City of Portland
Development Review Application
Planning Division Transmittal form

Application Number: 2012-421 Application Date: 1/31/2012 12:00:00
CBL: 130-G-007 AM
Project Name: Jabbar's Auto Sales
Address: 710 Forest Avenue

Project Description: Office warehouse to pre-owned automobile dealership

**RE: Conditional Use and Level I Site Alteration Applications
710 Forest Avenue, Tax Map 130, Block G, Lots 7, 8, 12 and 13**

L3.0

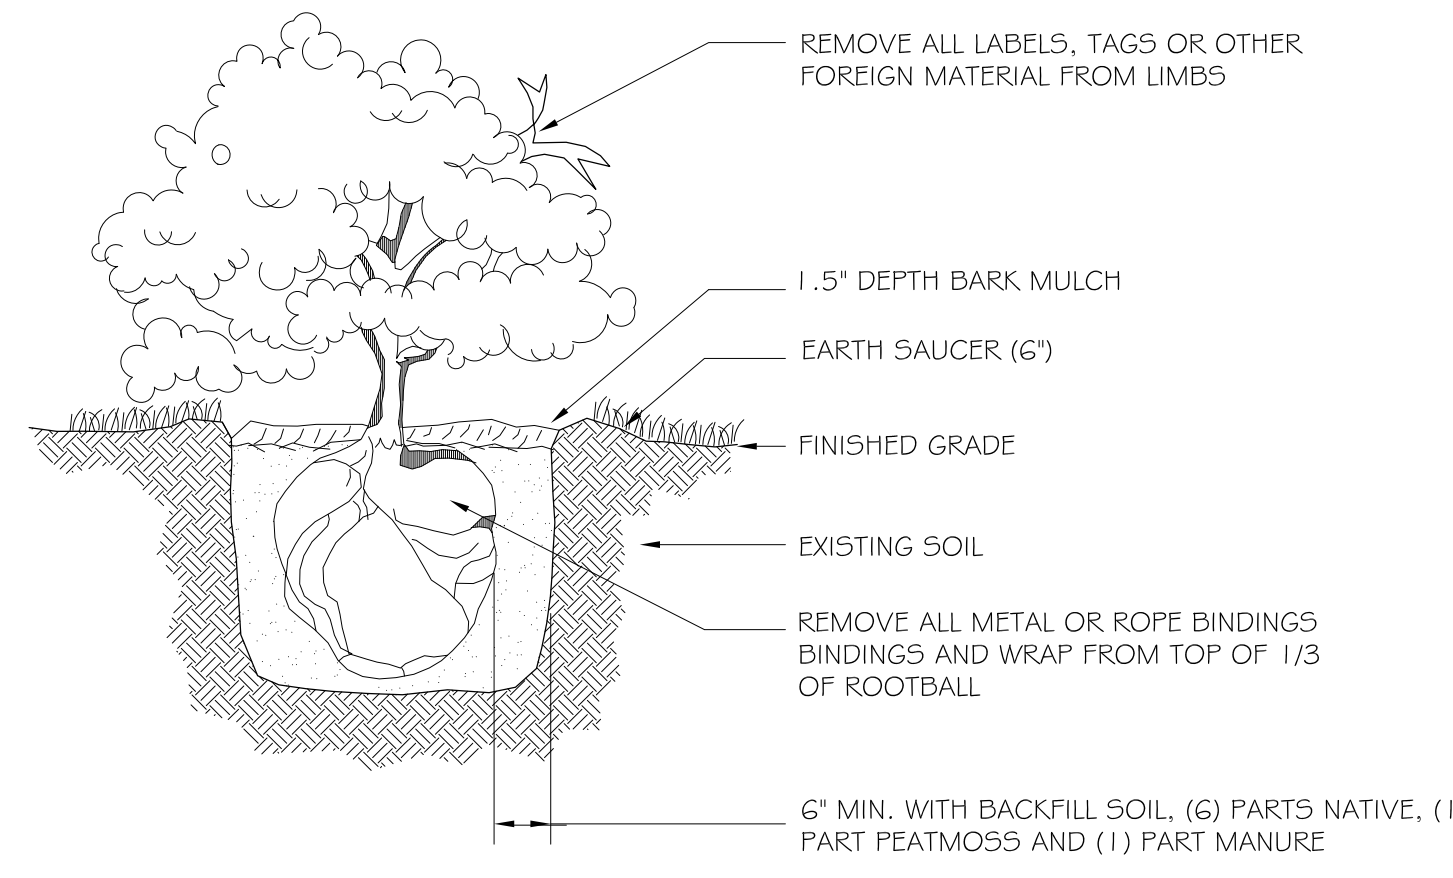
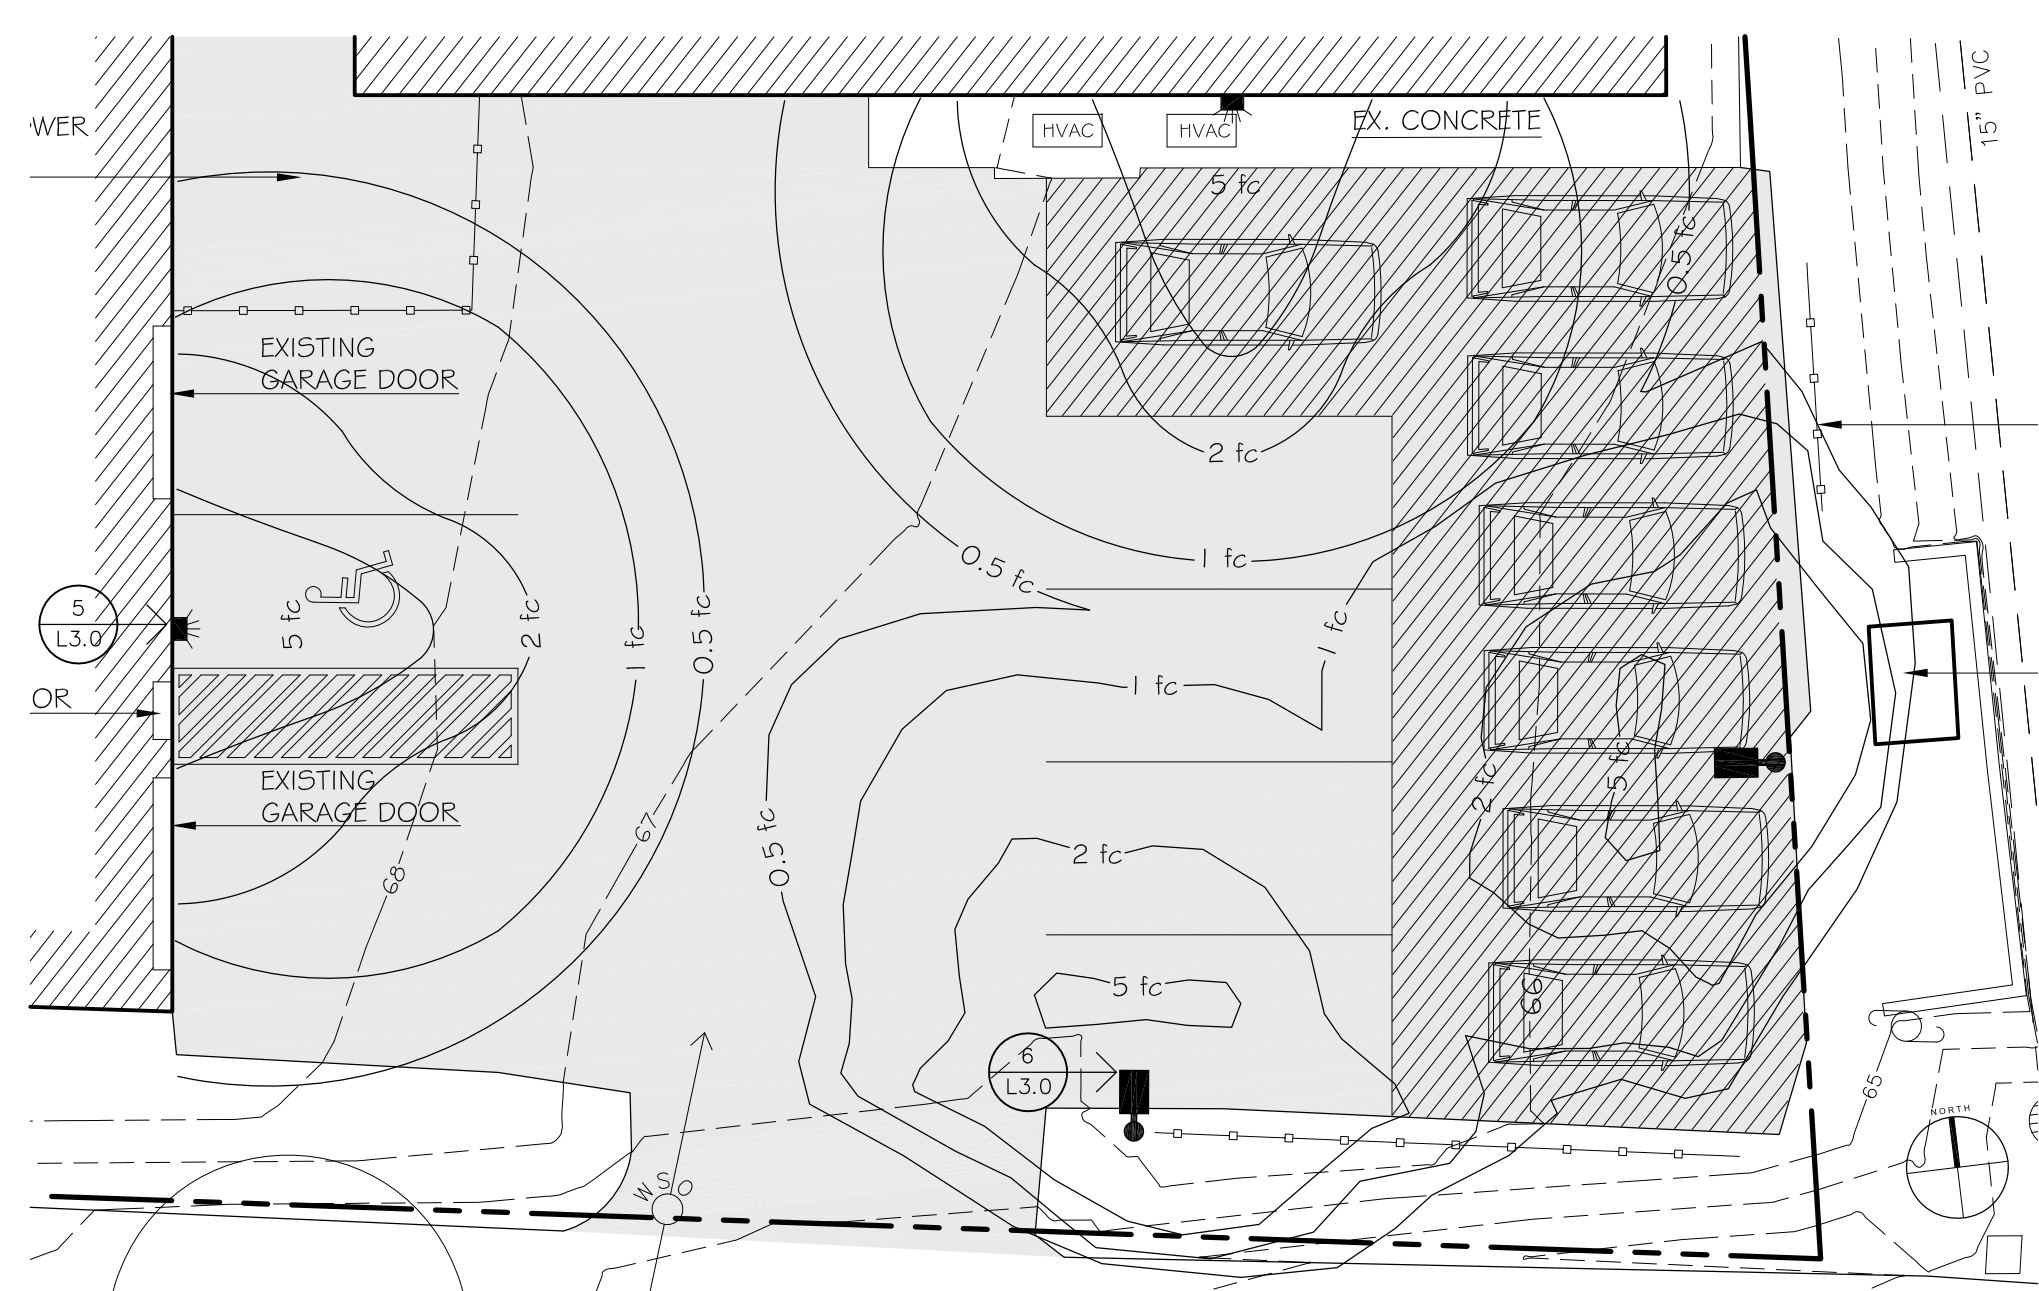
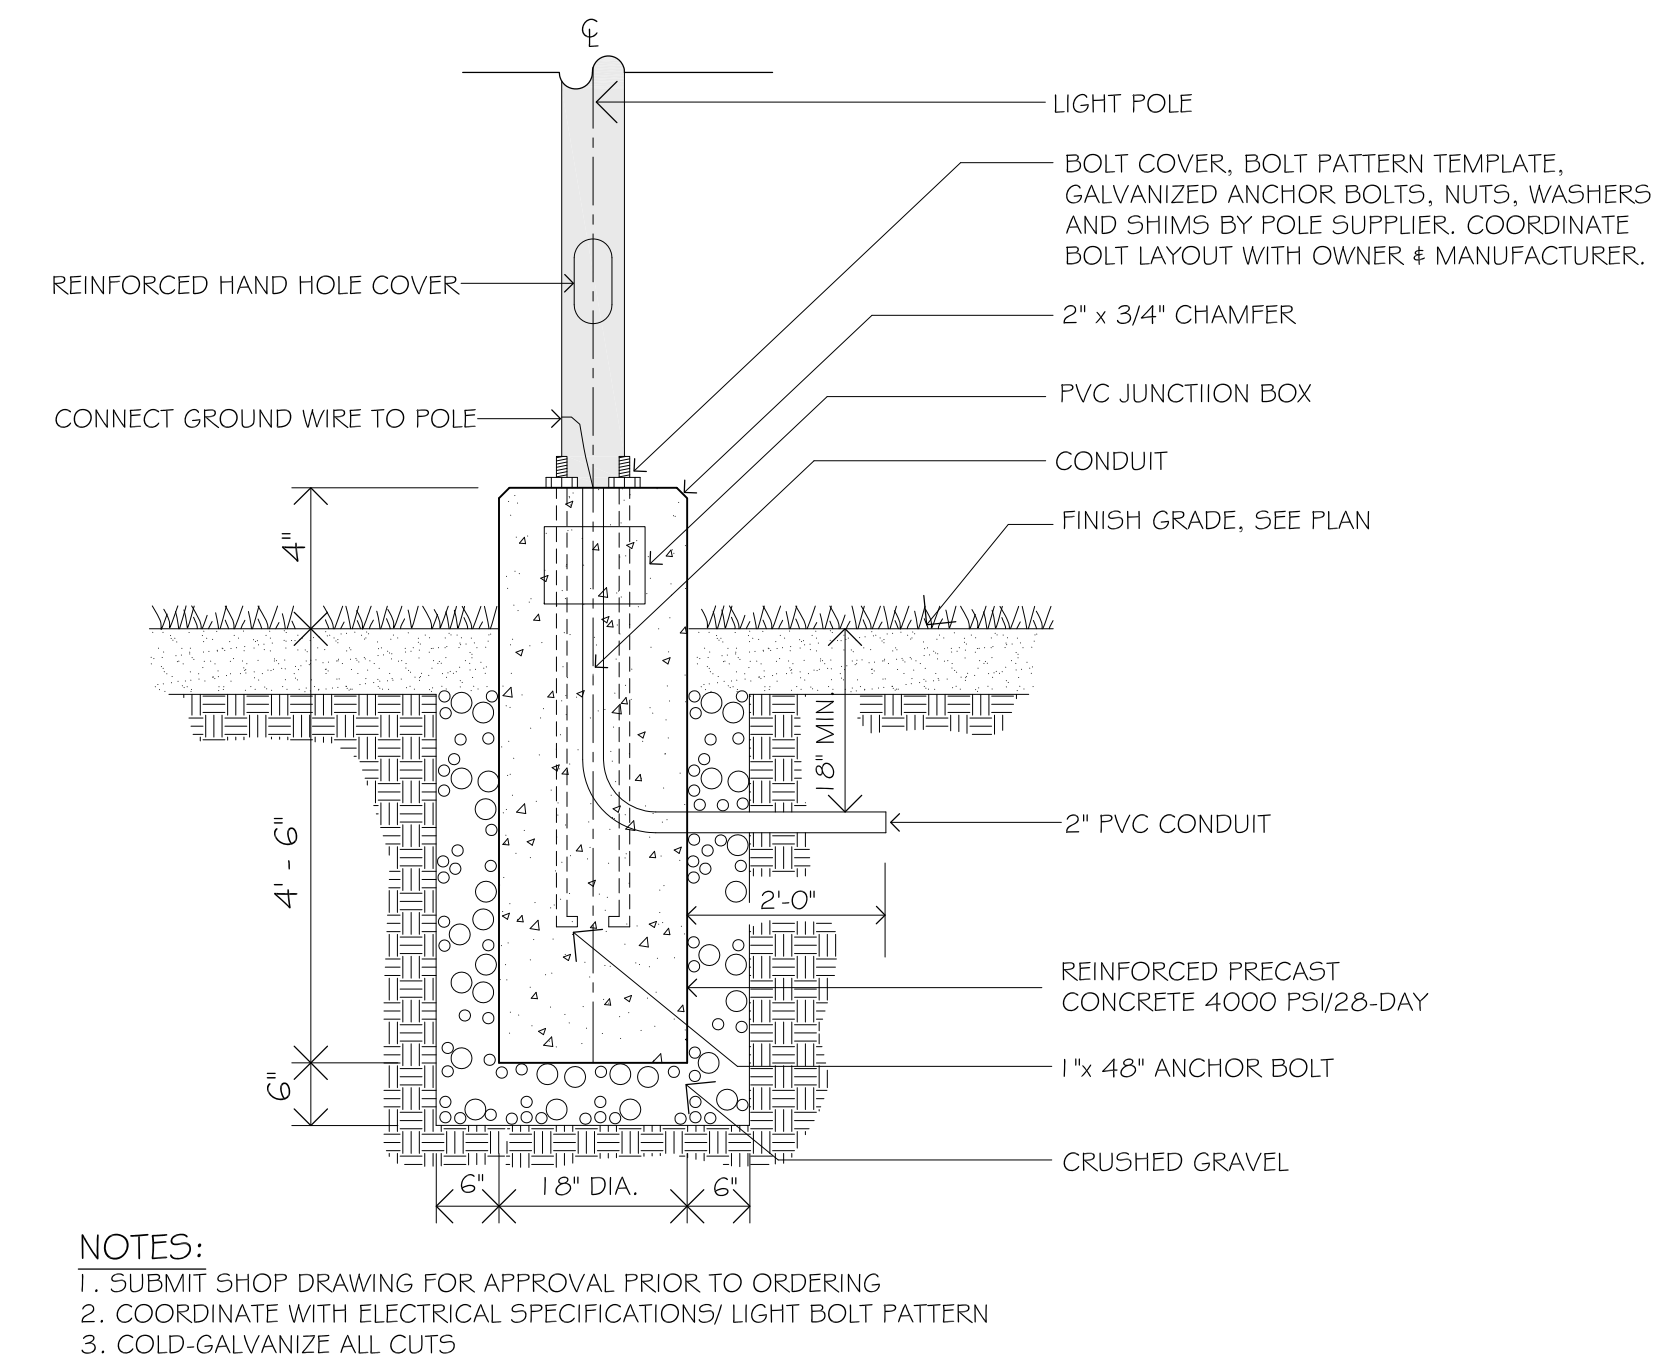
The attached revised site plan identifies two proposed secure bicycle parking spaces in conformance with Section 1 of the Technical Manual.

The attached revised site plan identifies three (3) areas for snow storage. The proposed landscape buffer plants have been selected to tolerate the proposed snow loads.

RECORD OWNER: Boulette Realty, LLC 710 Forest Avenue Portland, Maine	DRAWN BY: MLC	PLAN DATE: 1/30/2012
04102	CHECKED BY: JDN/TPB	SURVEY DATE: Dec. 2011/Jan. 2012
FIELD BOOK: FB 397 & Topcon Ranger	INSTR.: Topcon GPT-3003W & Topcon Hyper II GPS	SCALE: 1" = 20'
	JOB NO.: 2111269B	SHEET NO.: 1 of 1

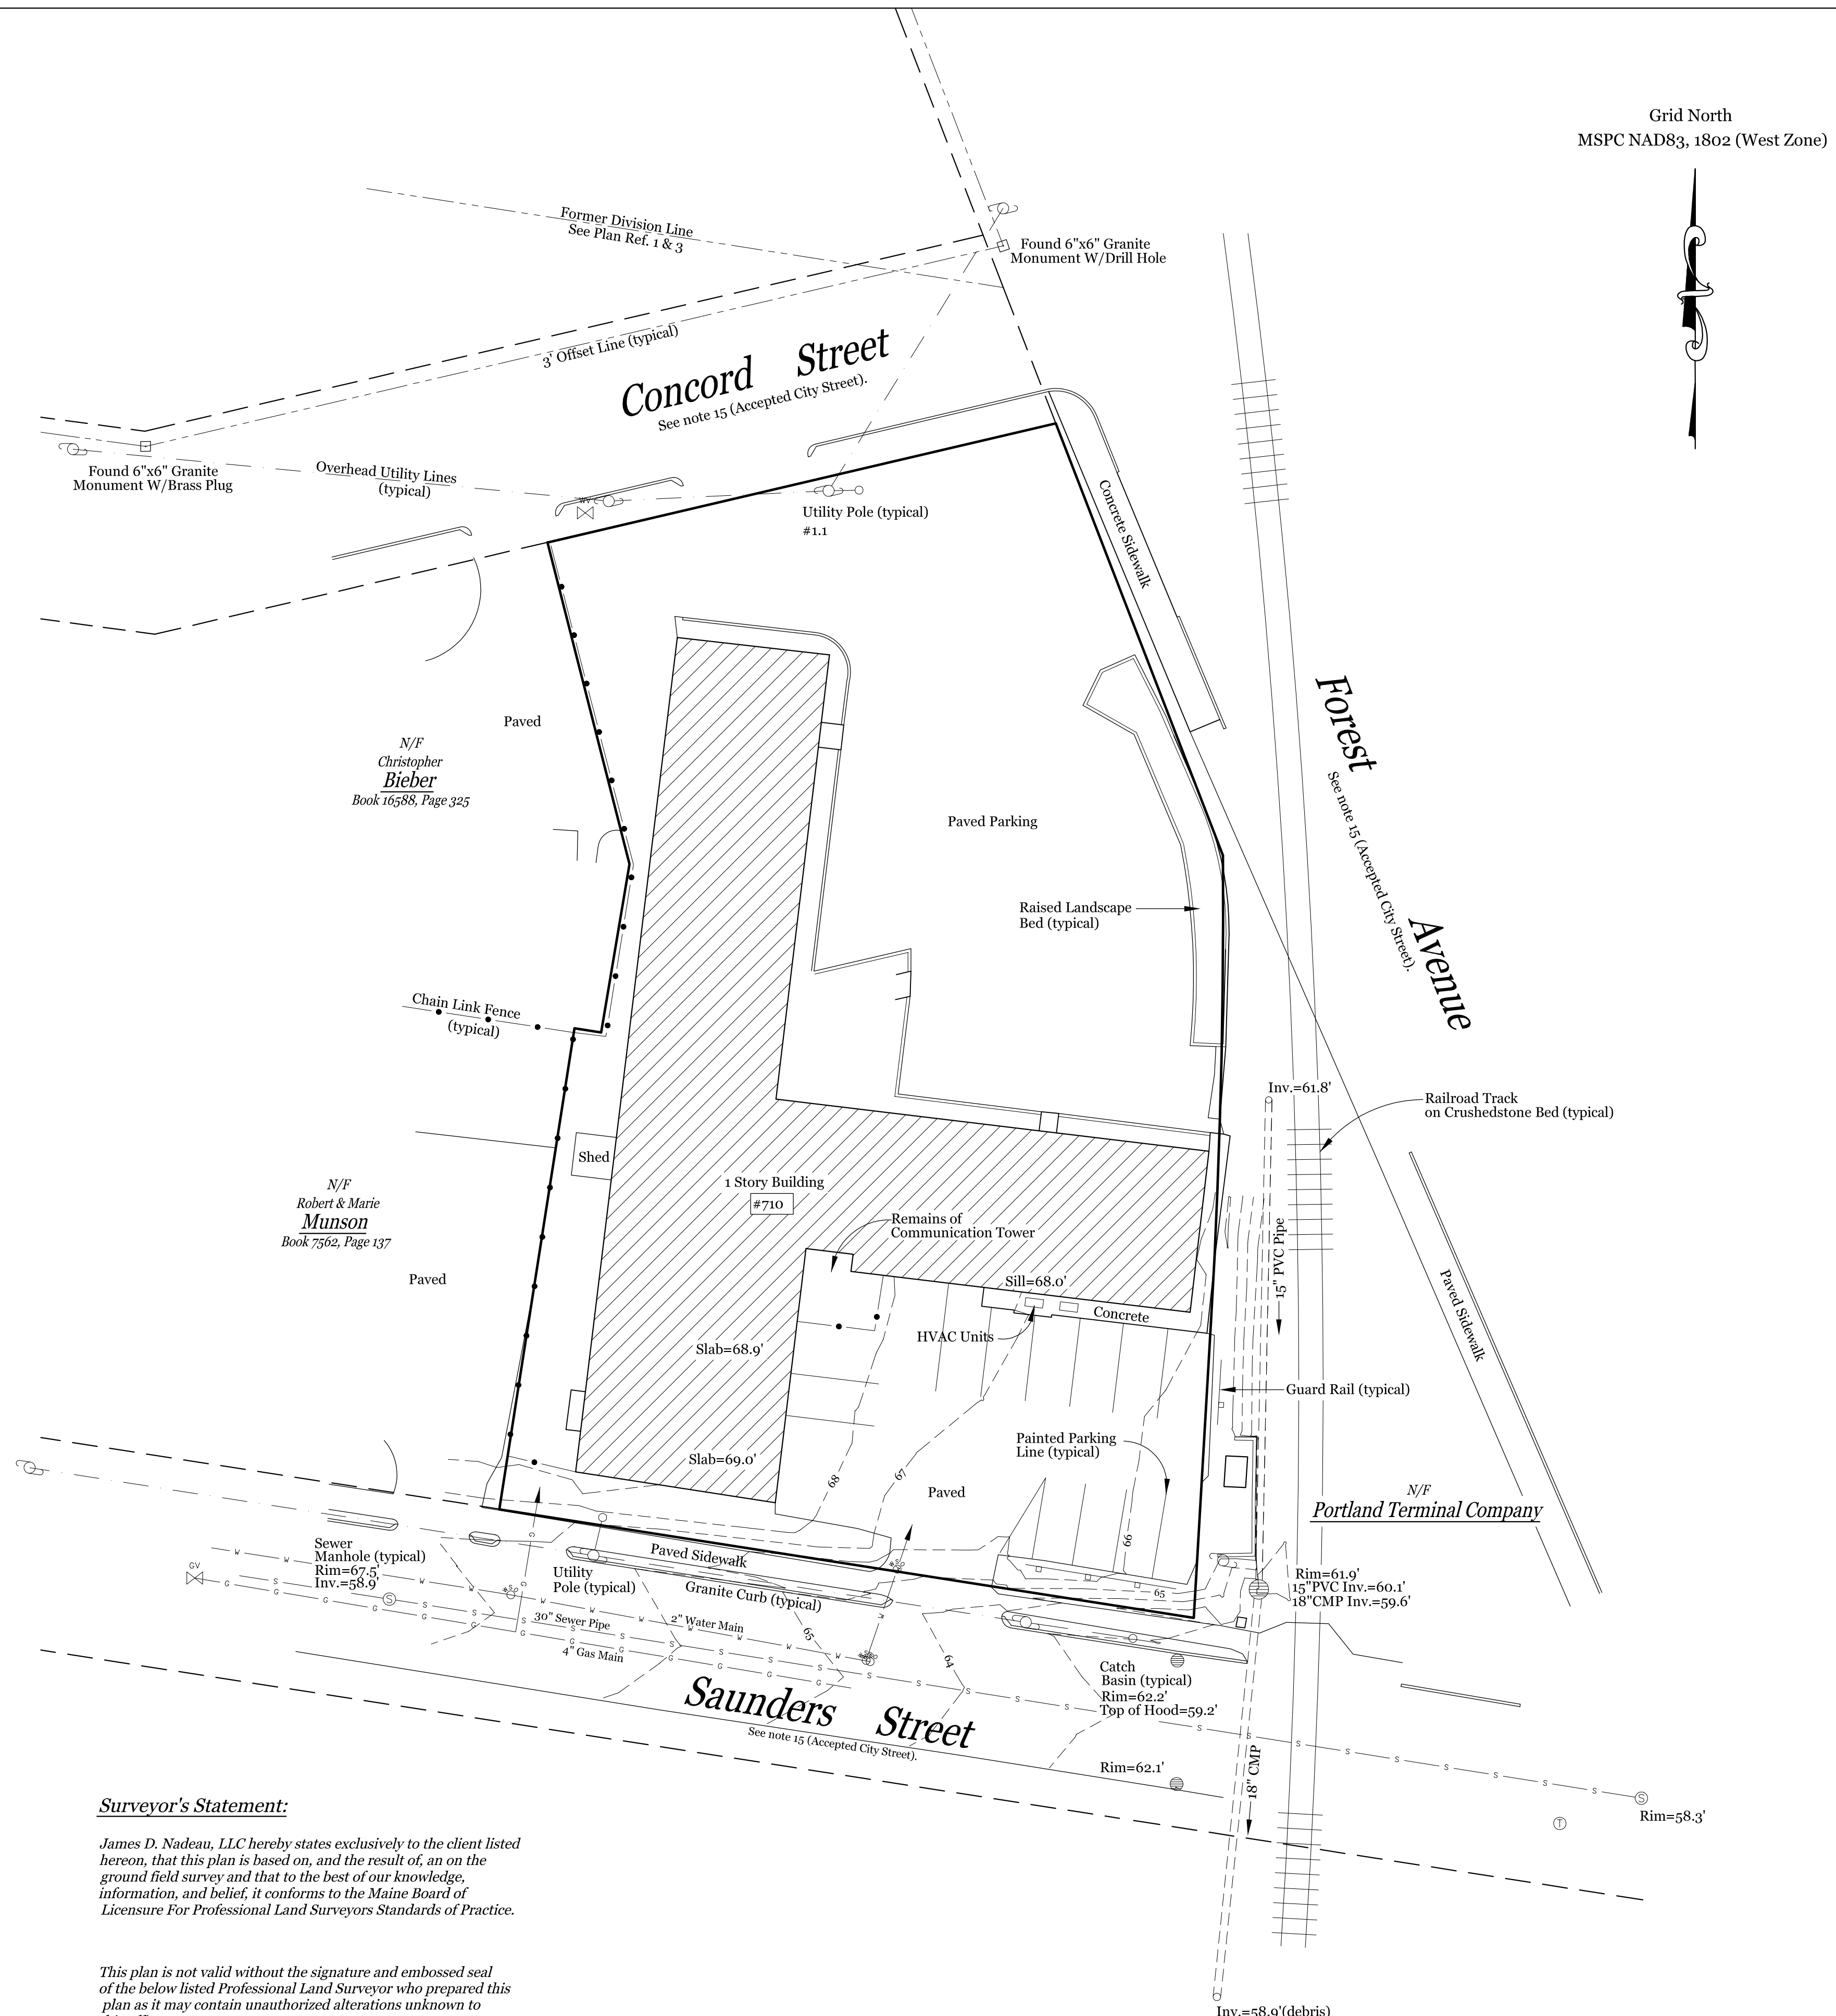
The State Plan Coordinates have been addressed on the plan.

1. A stamped survey plan is required. Property corners will need to be set upon approval and before commencing work. Please note that "approximate boundary lines" do not meet City standards
